COUNTY COUNCIL'S RESPONSE TO CONSULTATION ON THE FOLLOWING DEVELOPMENT PROPOSAL

Application No: 20/03638/F

Proposal: Variation of condition 1 (time limit) of 18/02169/F - proposed extension of temporary use of eastern part of southern taxiway for car processing

Location: Heyford Park, Camp Road, Upper Heyford, Bicester

Heyford Park - Site Perimeter Security Arrangements

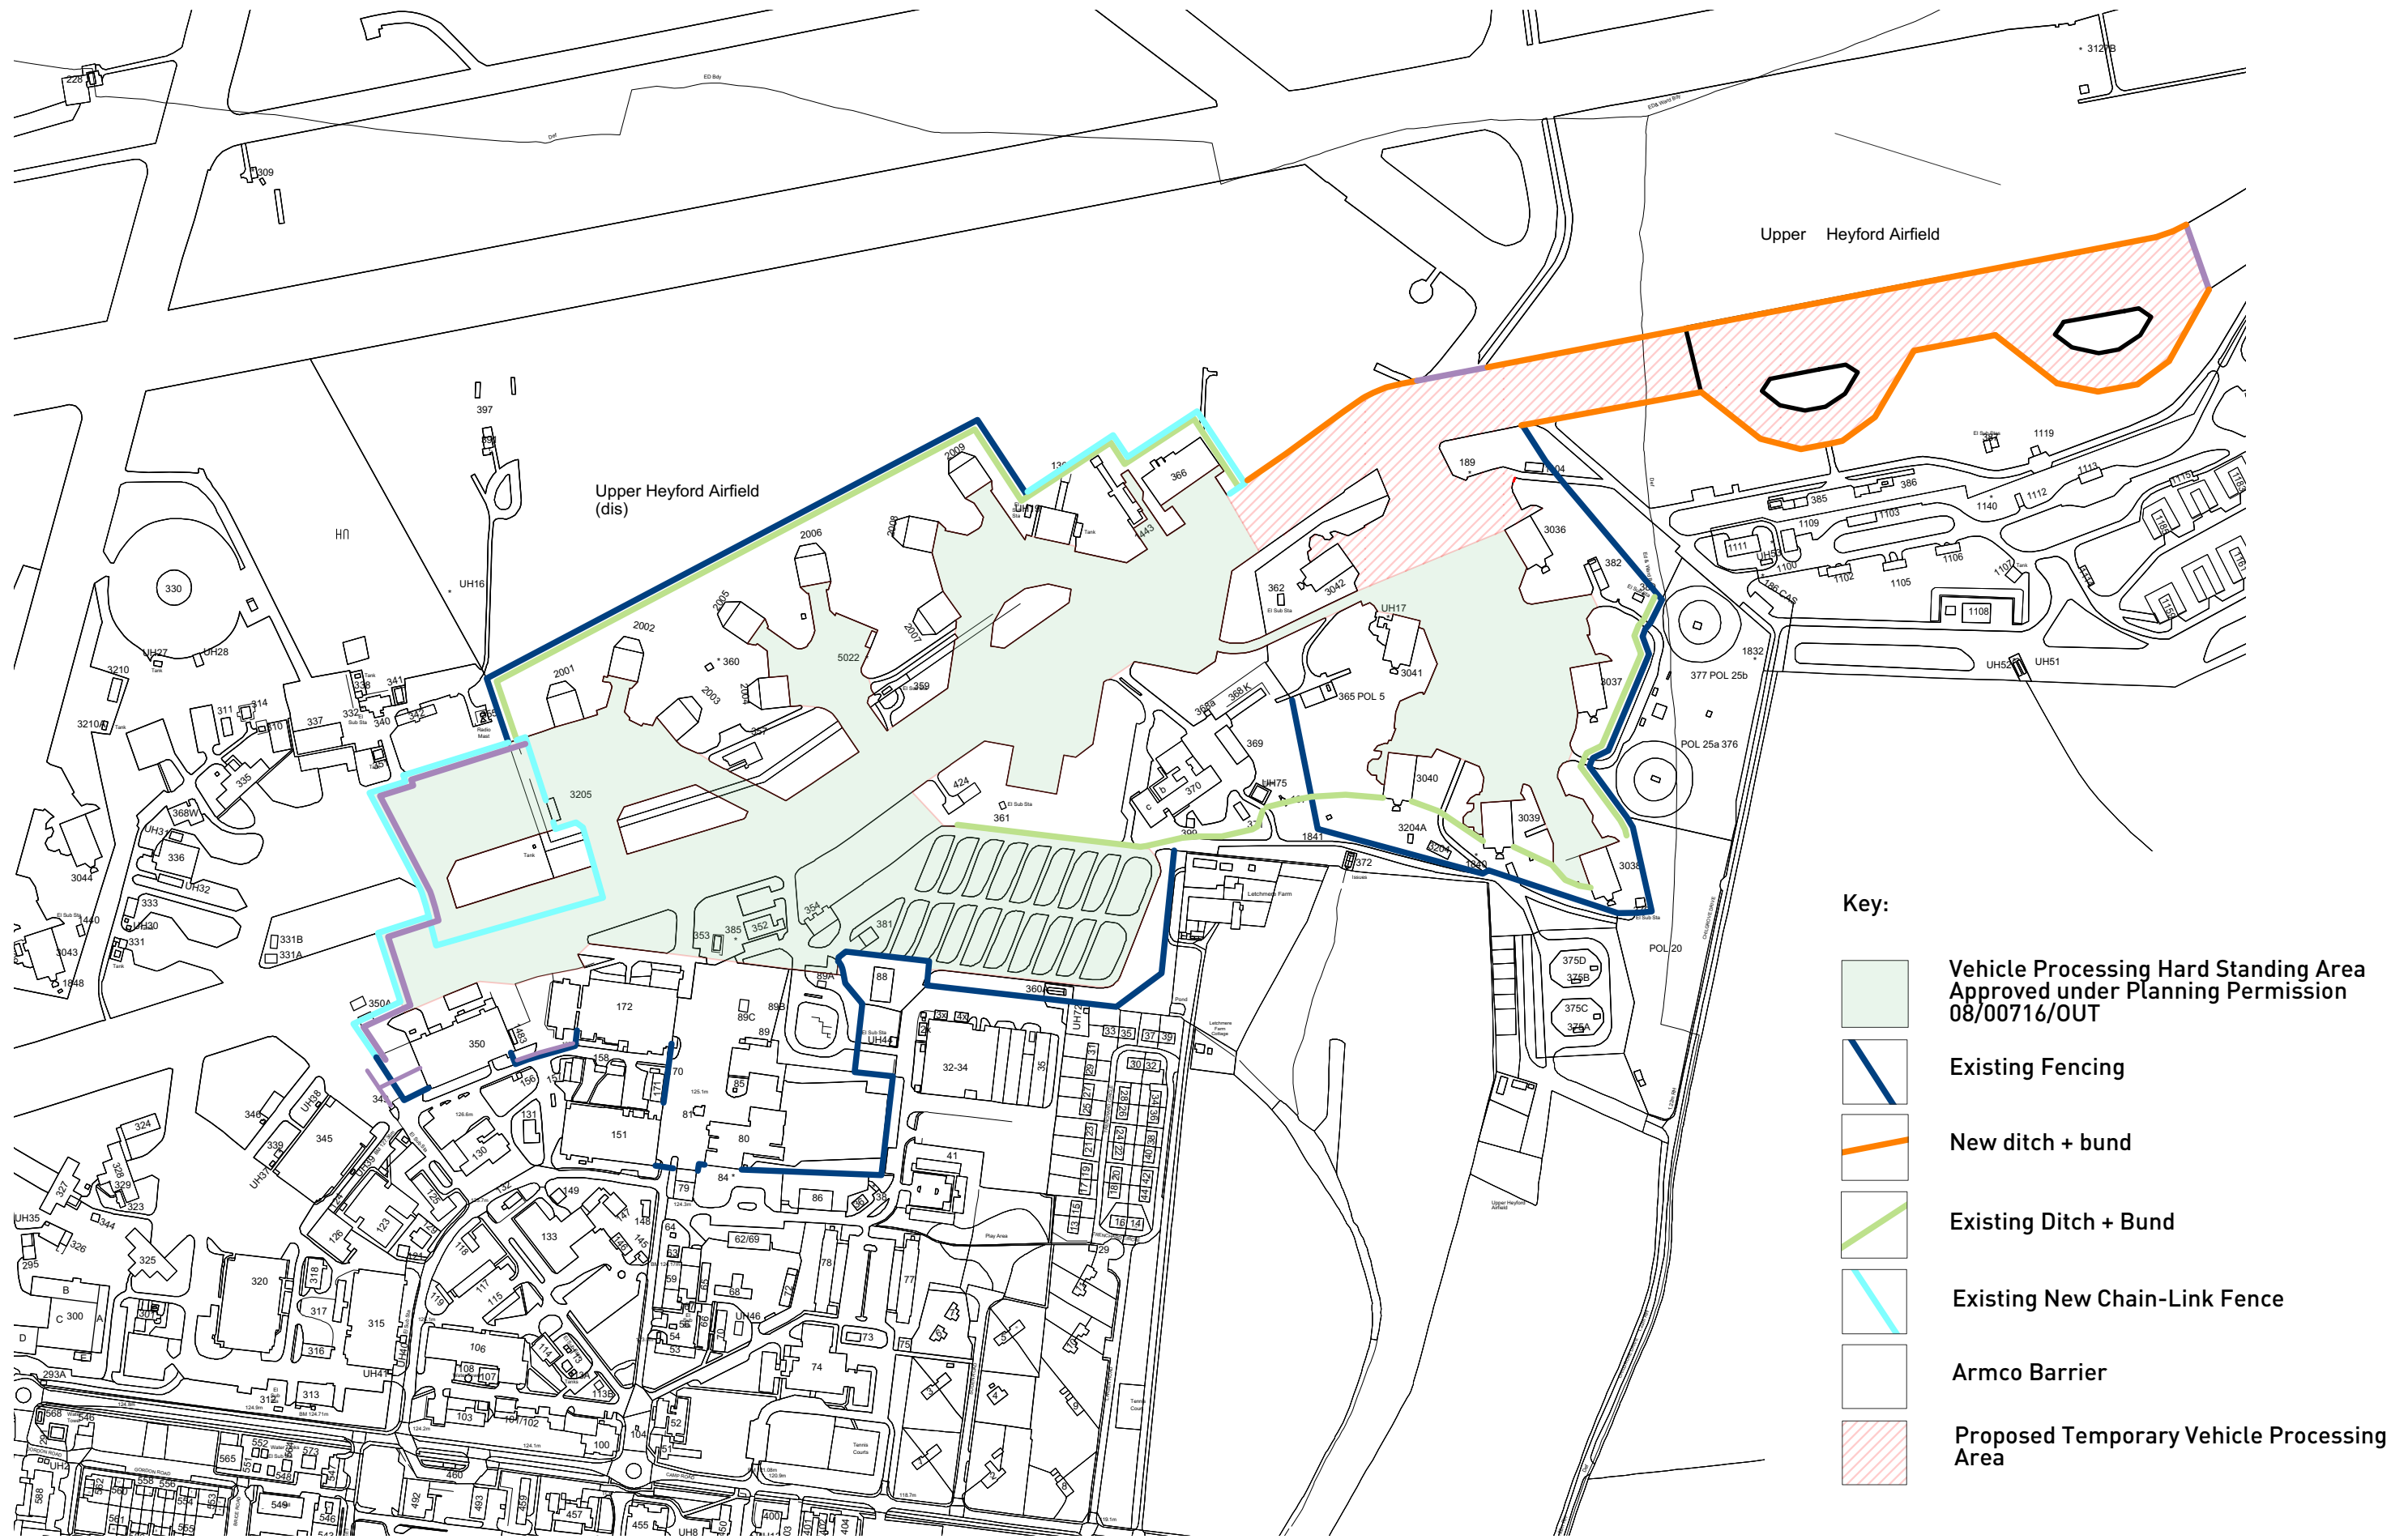
- The alignment of the Aves Ditch through the site should be safeguarded.

It should be noted that the alignment of the Aves Ditch restoration has not been fully clarified and finalised so this extension of the temporary permission could preclude restoration to an alignment inside and across the Flying Field.

In this respect a condition is required that allows for the eventuality of a bridleway route to be established across the temporary processing area on a suitable alignment whilst the temporary processing permission is running. This can be limited to only being an option if the hybrid application is refused and/or if a route across the Flying Field is deemed to be the best solution for Aves Ditch. At the appropriate juncture this can be agreed between Dorchester, Paragon and the County.

Aves Ditch bridleway alignment protection. Temporary extension of the processing area shall include a provision for Aves Ditch bridleway to be routed safely through the site in the event of application 18/00825/HYBRID being refused and/or if the route through the processing site and flying field is deemed to be the best route for the restored route of Aves Ditch bridleway.
